Your reference SSD 7237
Our reference: EF13/5058, DOC16/243859-01
Contact: J Goodwin 9995 6838

SSD 7237 – PARRAMATTA SCHOOLS RE-DEVELOPMENT PROJECT – EIS

PETER MORRALL
A/Unit Head, Metropolitan Infrastructure
NSW Environment Protection Authority

REDEVELOPMENT OF ARTHUR PHILLIP HIGH SCHOOL AND PARRAMATTA PUBLIC SCHOOL

Figure 29: Sensitive Receiver/Noise Monitoring Locations (source: Applicant)

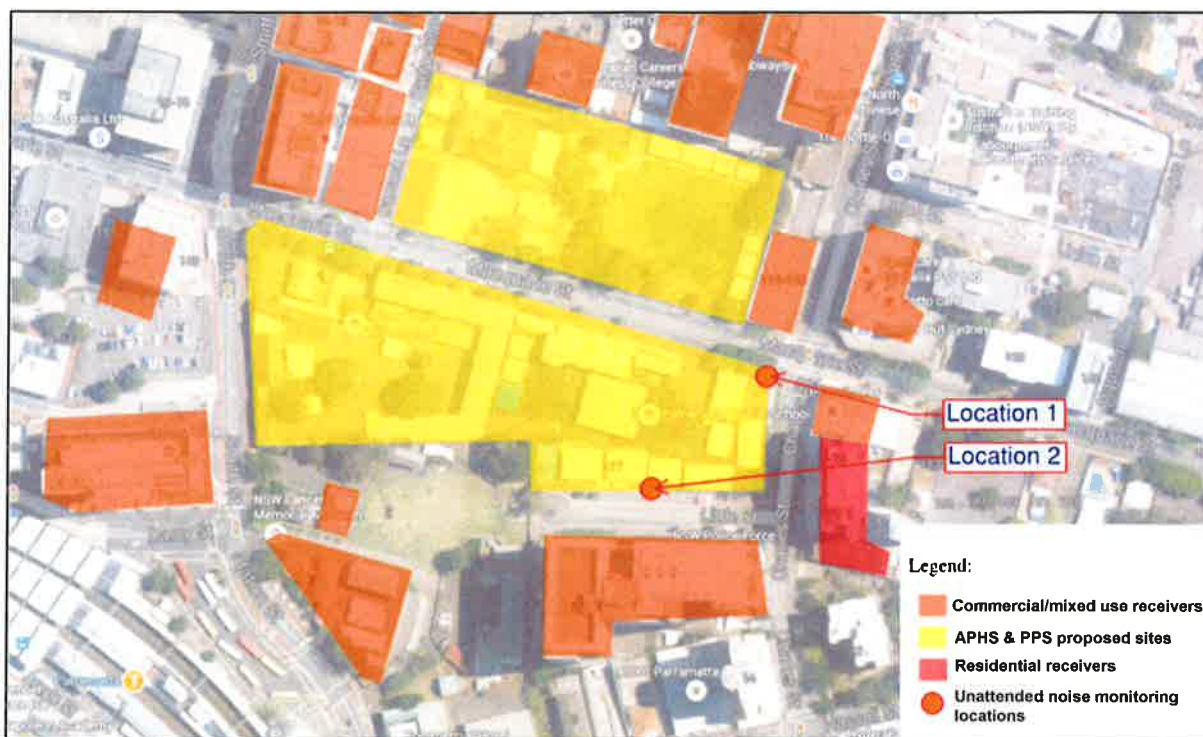
The EPA is concerned that Figure 1 to EIS Appendix 10 (Noise and Vibration Planning report) indicates that the proponent appears to have disregarded the INP guidance material about noise monitoring required to establish the background noise levels for the project. The EPA is particularly concerned that :

- (a) background noise monitoring was undertaken at 2 locations on school grounds rather than at the most affected noise sensitive receivers;
- (b) background noise monitoring was undertaken during the first term of school rather than during a school holiday period when school activities would be unlikely to affect measurements;
- (b) Appendix 10 does not include the daily graphs of noise logger measurements;
- (c) attended monitoring was likely to have been undertaken at street level, whereas the most affected residences are located above street level; and
- (d) the periods of adverse meteorological conditions referred to in section 3.2.1 (p.3) of EIS Appendix 10 have not been shown against the logger measurements.

The EPA notes that the legend to Figure 1 to EIS Appendix 10 appears to inaccurately portray the location of the development site.
